**KIRKLEES METROPOLITAN COUNCIL
INVESTMENT & REGENERATION SERVICE**

DELEGATED DECISION TO DETERMINE PLANNING APPLICATIONS

Reference No:	2024/62/90786/W
Site Address:	21, Woodhead Road, Lockwood, Huddersfield, HD4 6ER
Description:	Erection of porch
Recommending Officer:	Joanna Rednall

HOUSEHOLDER DELEGATED REPORT

Drawing Title/Issue
General Arrangement as Proposed

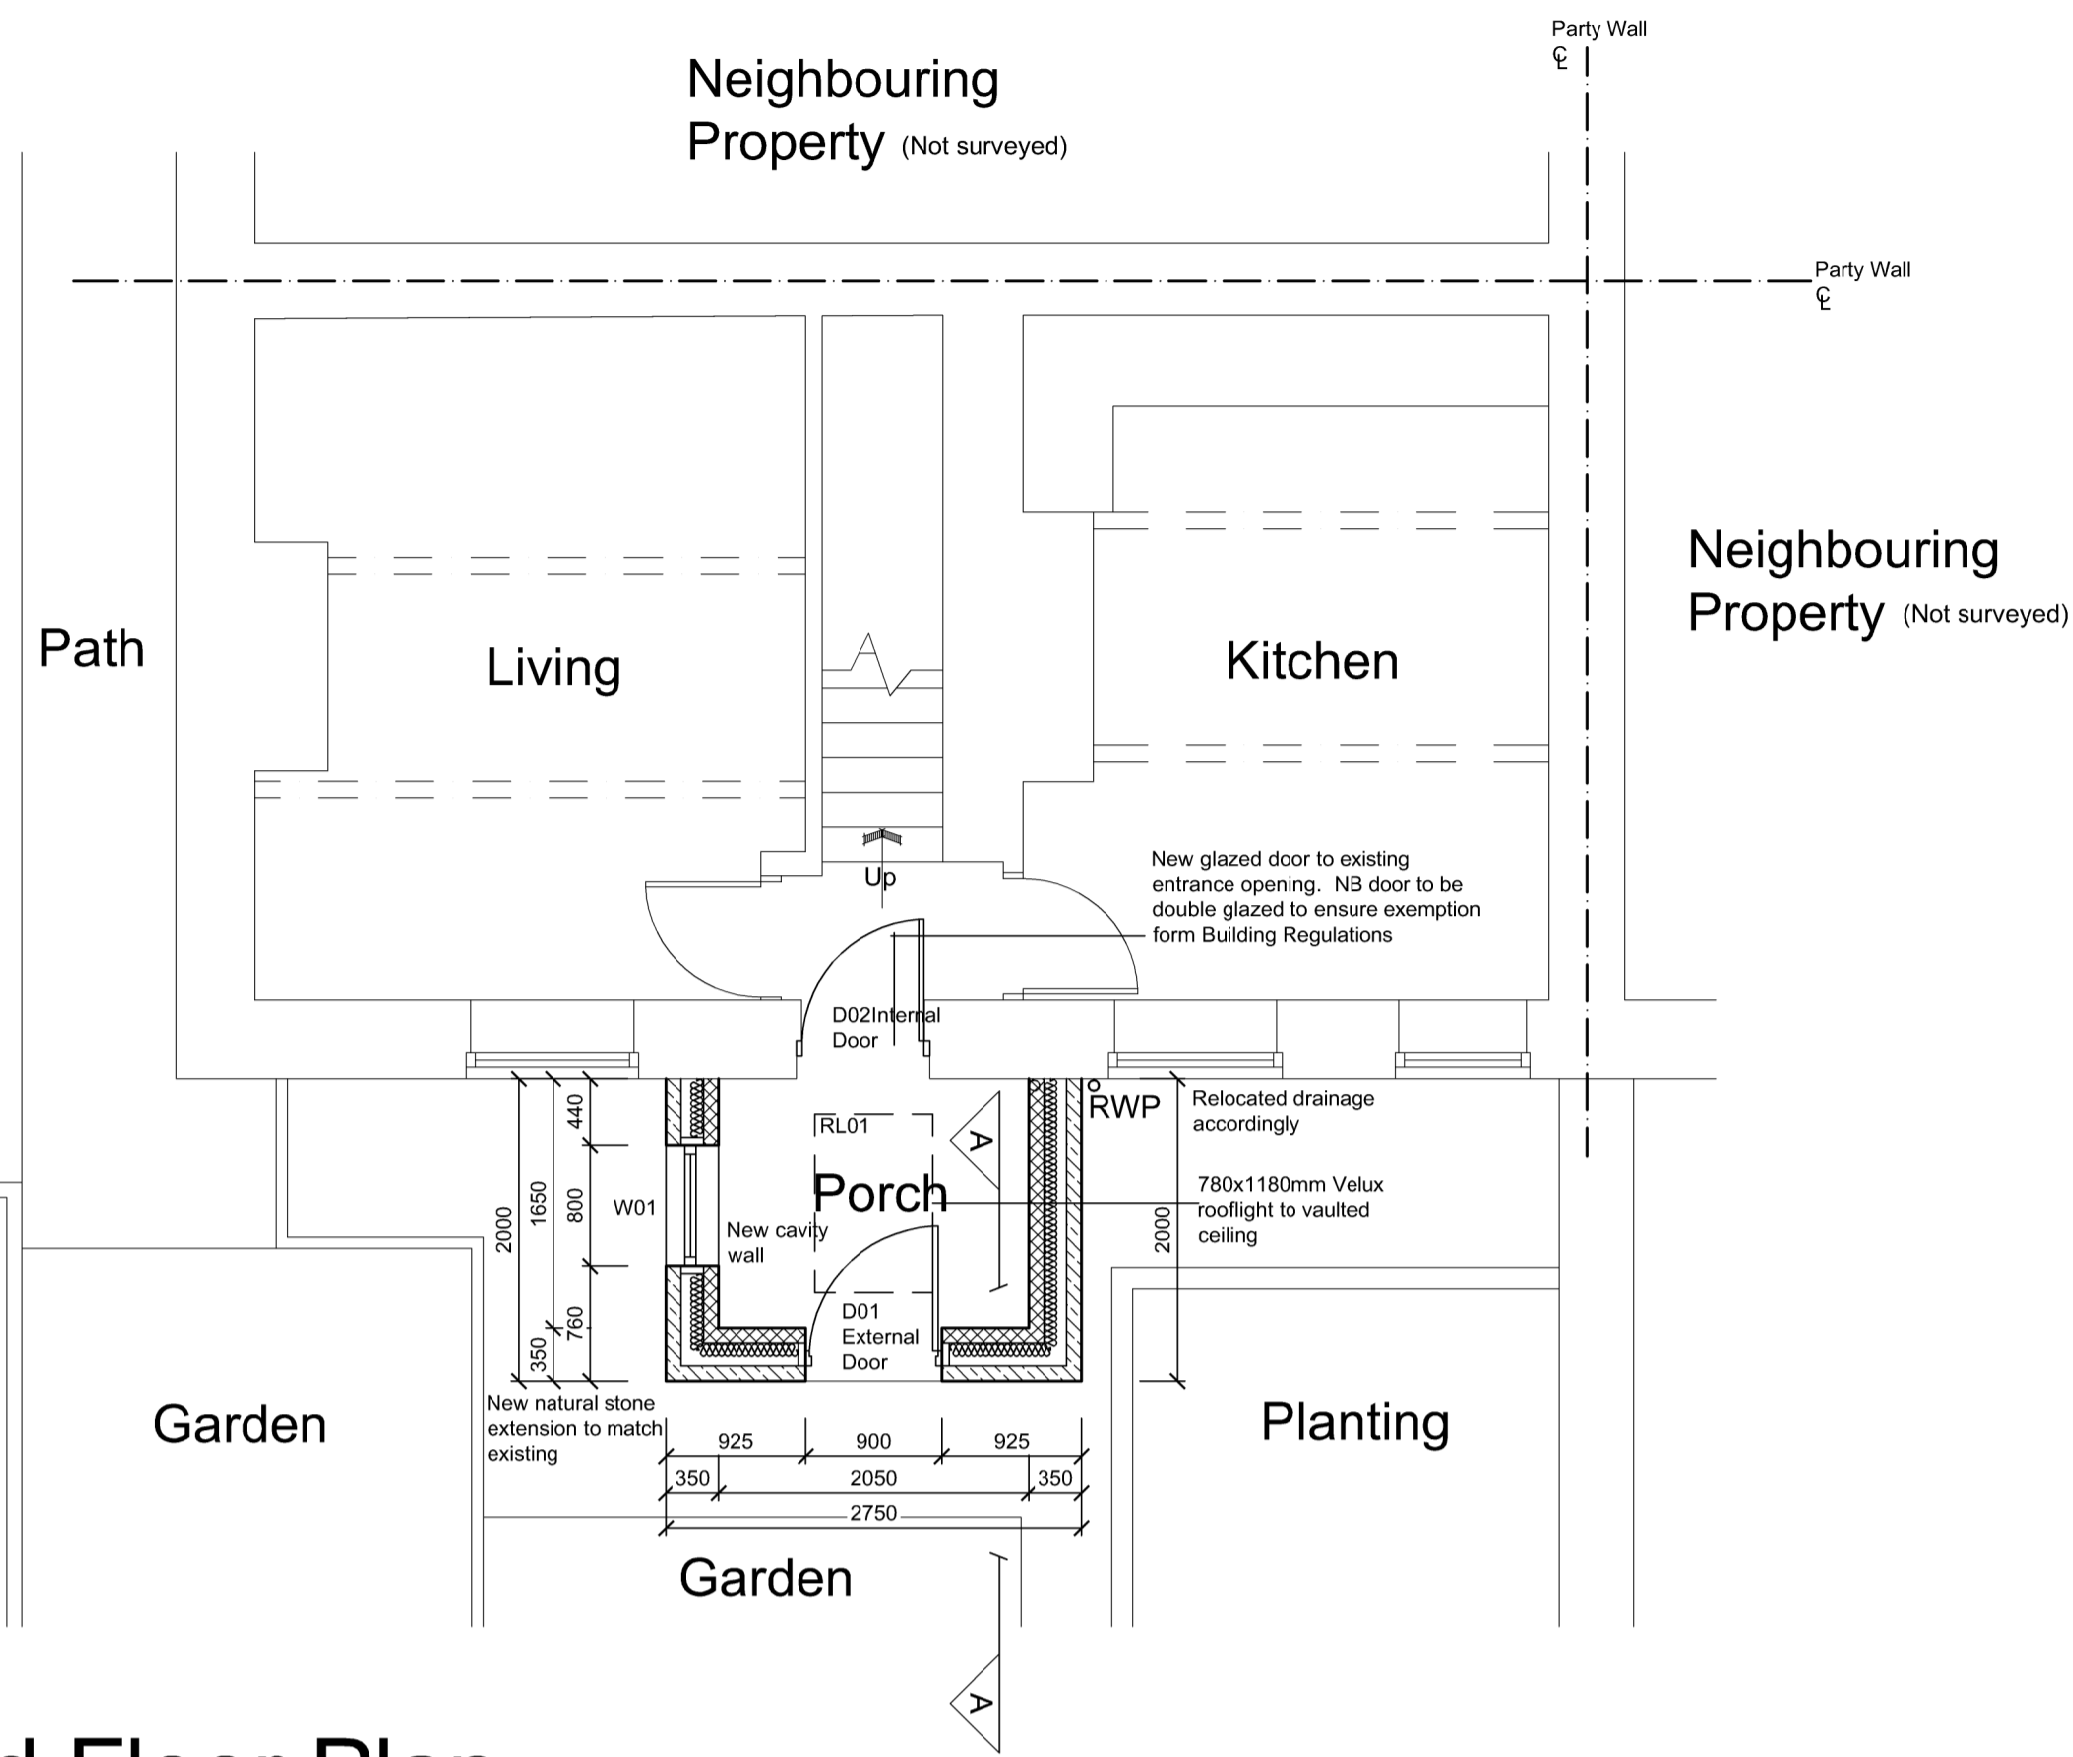
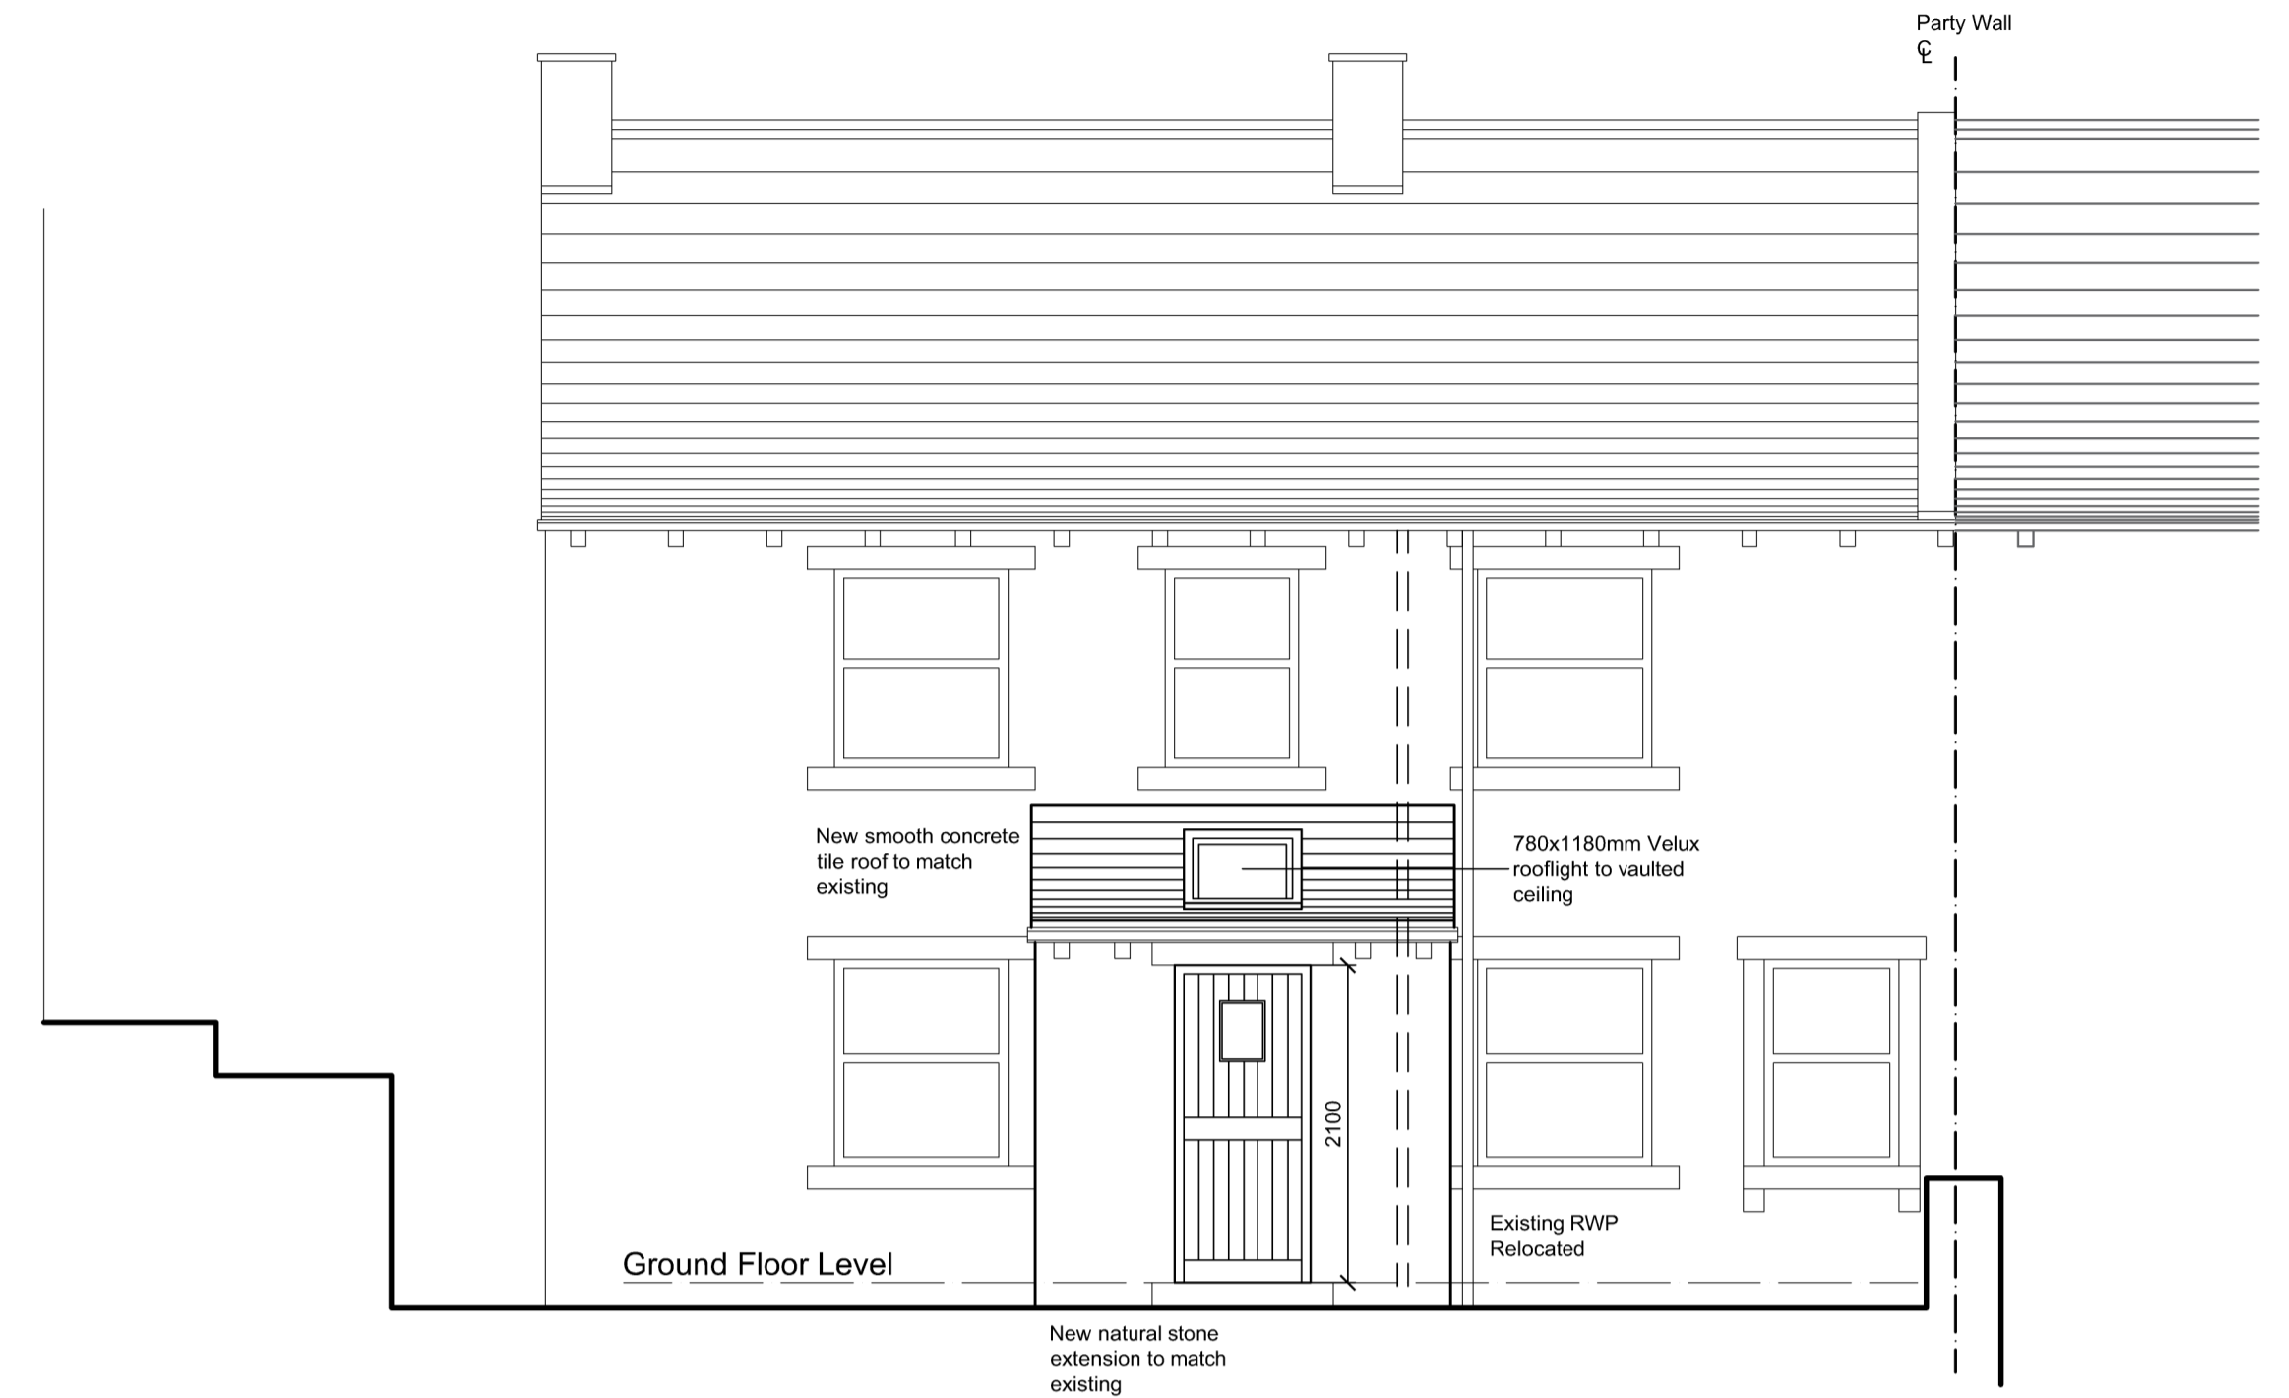
The measurements of the porch would be as follows:

- ~2 metre projection
- ~2.7 metre width
- ~2.5 metre eave height
- ~3.3 metre ridge height

The proposed construction materials are natural stone for the walls with concrete tiles for the lean-to roof.

There would be one Velux rooflight as well as one window within the south-west facing elevation.

It is not considered that the proposed works would cause detrimental harm to the residential amenities of this neighbour. The porch would be set ~3 metres off the shared boundary with blank elevation facing this neighbour, therefore would not be detrimental in terms of overlooking/overbearing/ loss of privacy.
